**CITY OF ALBUQUERQUE
PLANNING DEPARTMENT
May 22, 2013
DRB Comments**

PROJECT # 1009710

APPLICATION # 13-70546/ 70557

RE: Lots P-1 thru R-1, The Palisades Subdivision

PLAT OF
LOTS P-1-A & R-1-A
BLOCK 4 THE PALISADES

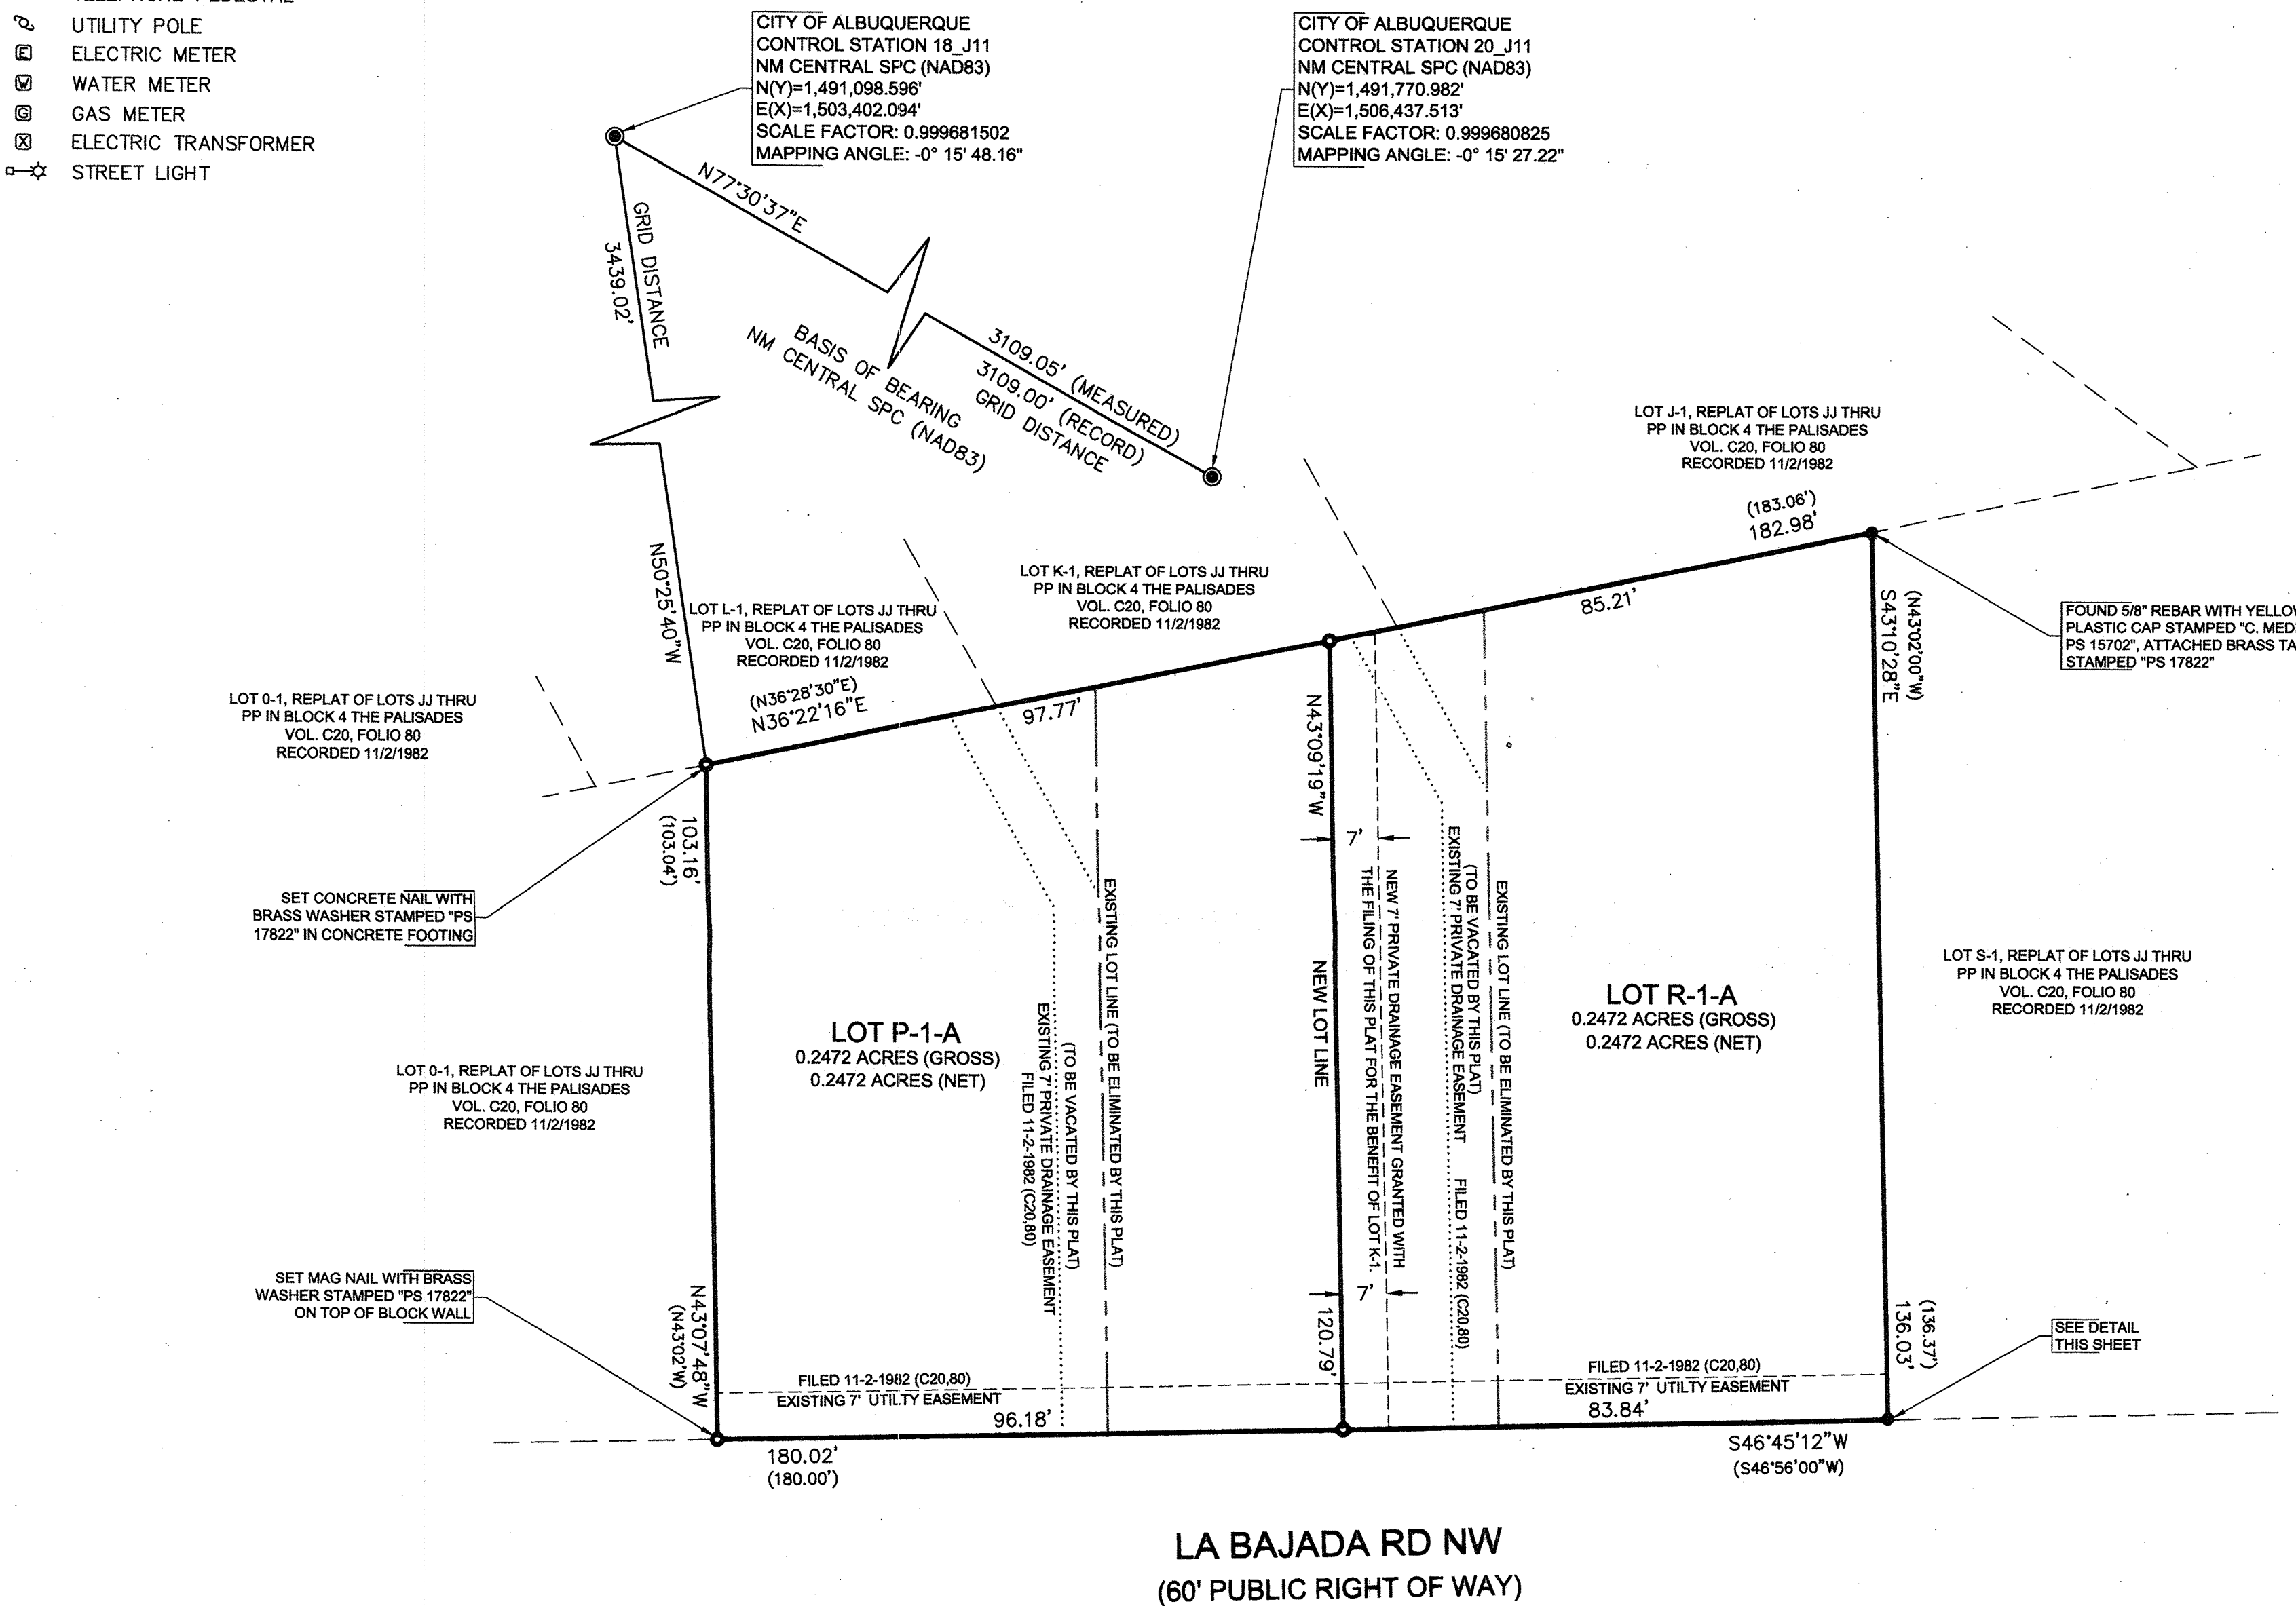
Vacating the private easements requires that the City be satisfied that the beneficiaries can agree to the action; it appears a drainage plan will be needed to demonstrate that uphill drainage rights are maintained.
